From:
Sent: 01 May 2025 11:43
To: DC Admin
Subject: Comments on Planning Application 2025/62/90768/E

Original Planning Application for dwelling at 2, Hopton Hall Lane 2024/93055

EAST ELEVATION
1:100

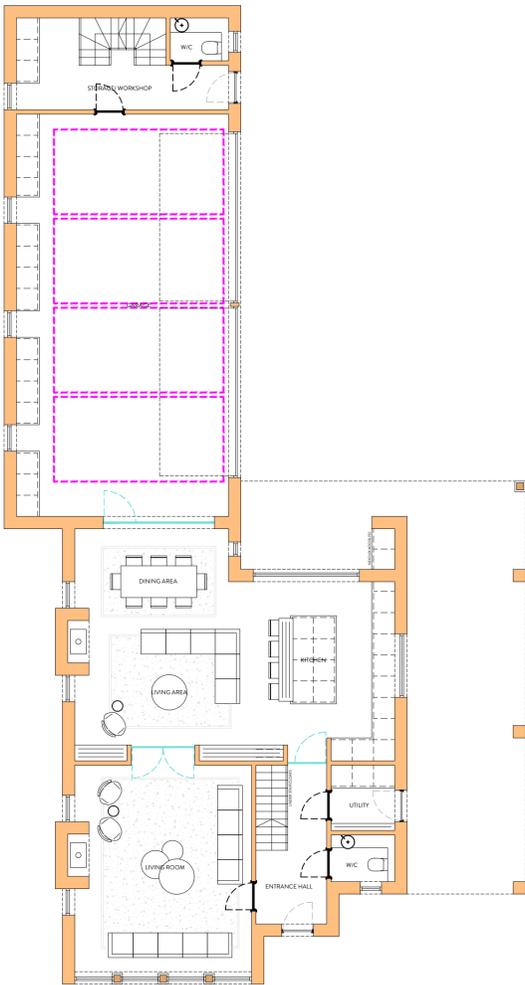
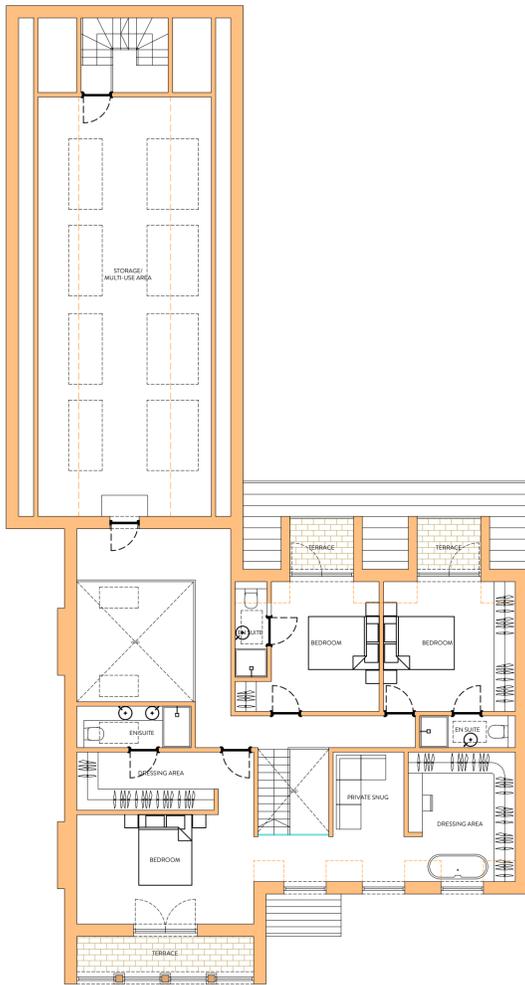
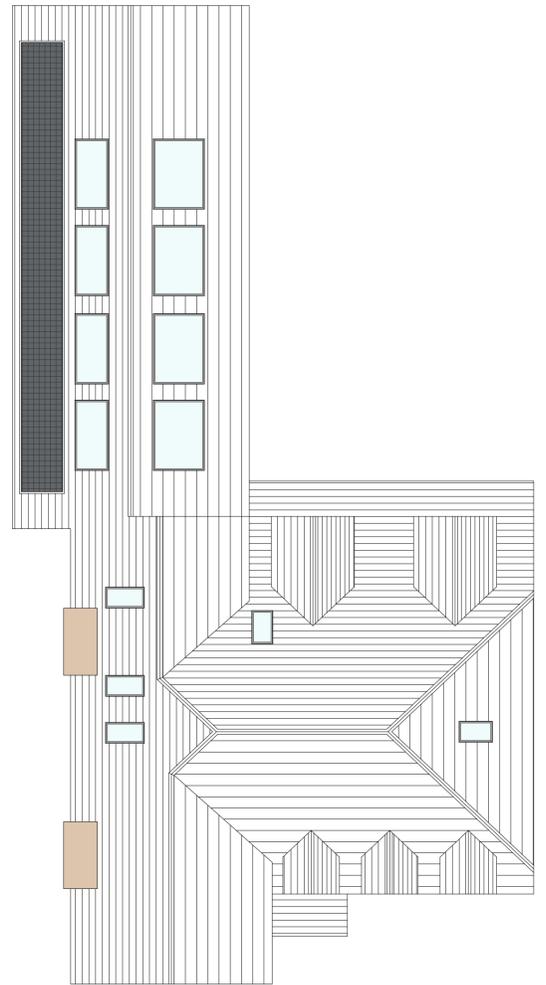
1. I am still concerned that the revised Planning Application will adversely affect the enjoyment of my property.
2. Unless the windows are below the current boundary, a dry stone wall 3 feet high, my property will be overlooked by the proposed development. This will affect my enjoyment of the garden at the rear of my house.

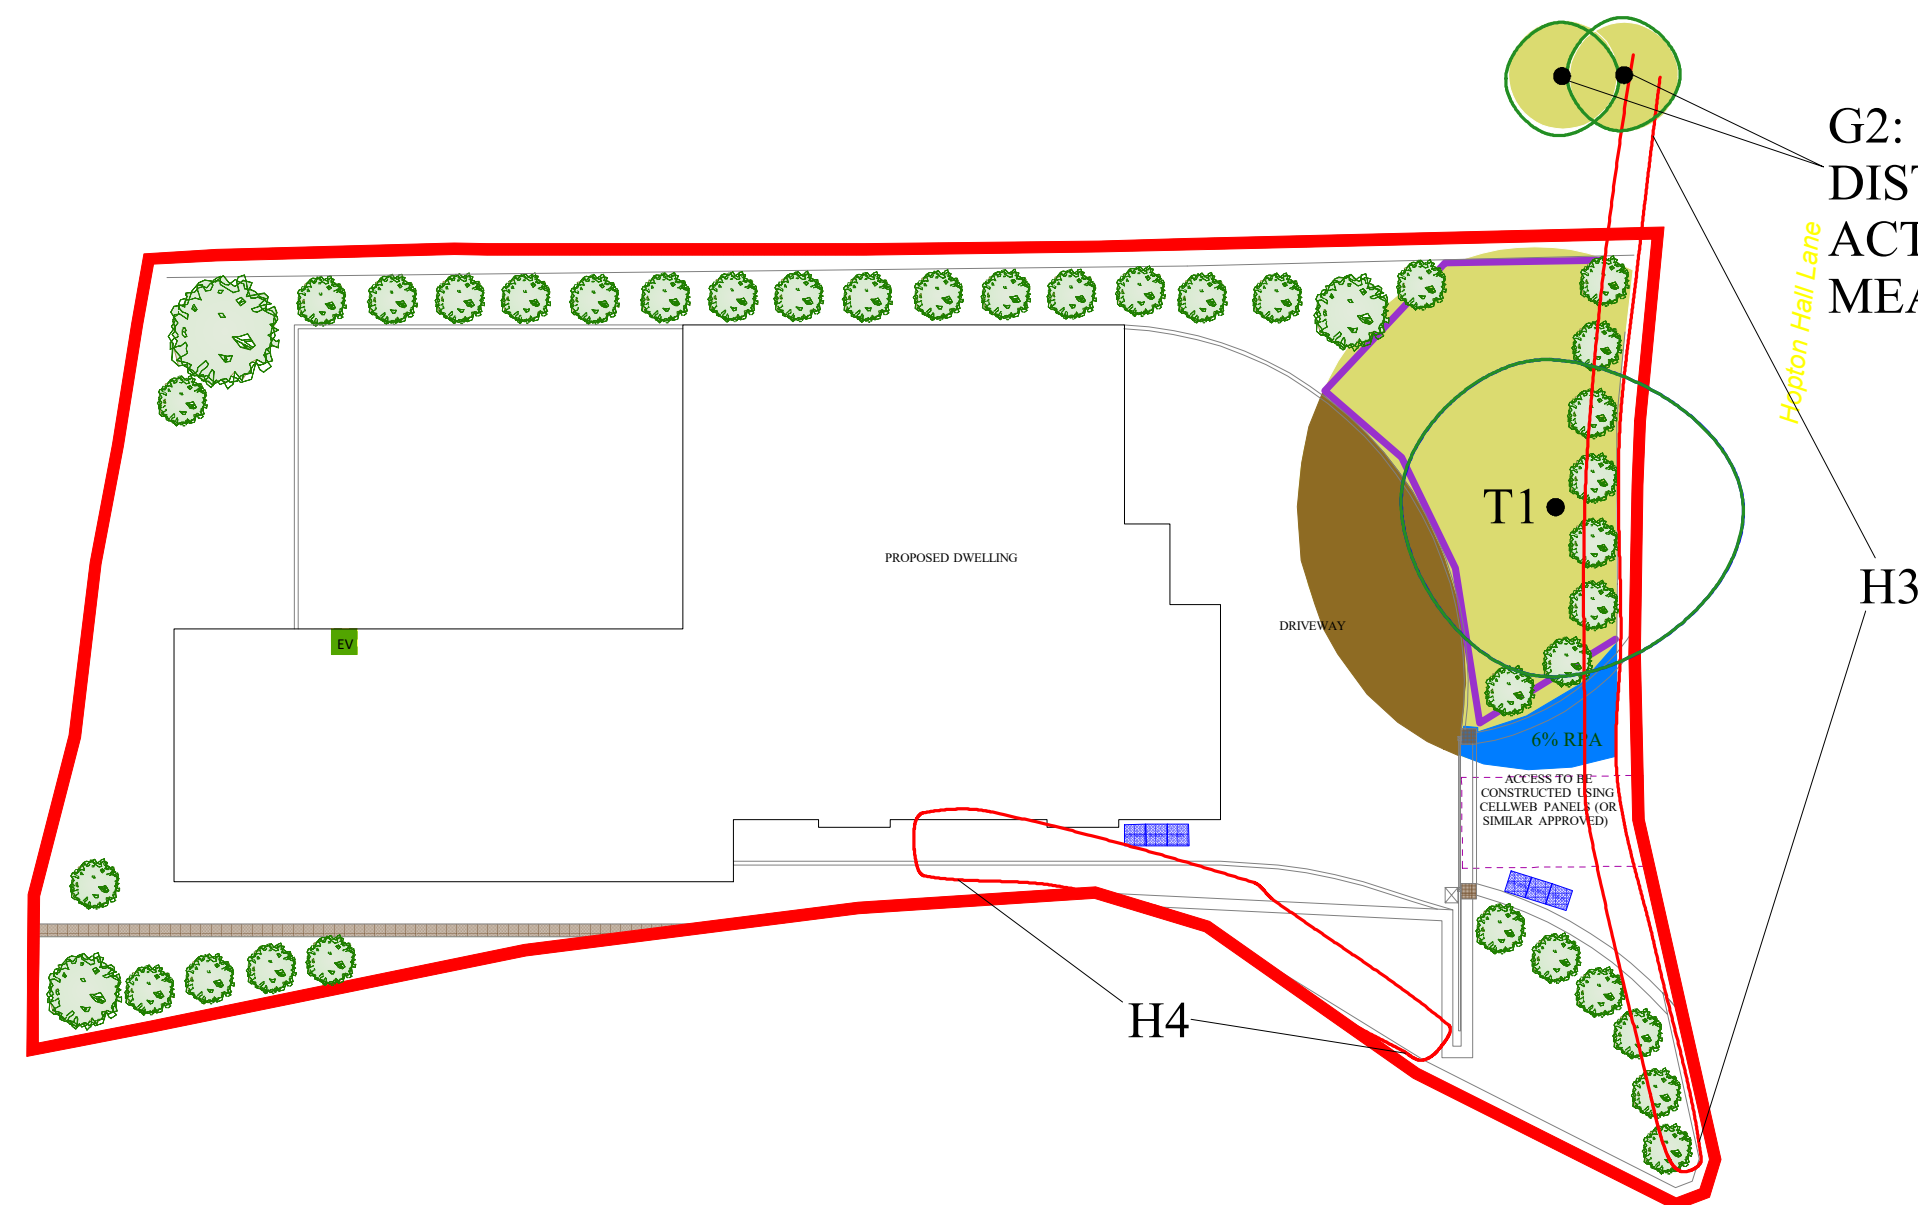
3. Currently, 2 Hopton Hall Lane is "screened" from the gardens at Nos 1 and 3 Fairways, by laurel and conifer hedging. The proposed development shows the removal of the laurel and conifer hedging that will only be partially replaced by ornamental trees that will not provide a "screen" between Nos 1 and 3 Fairways and the new building at 2, Hopton Hall Lane.
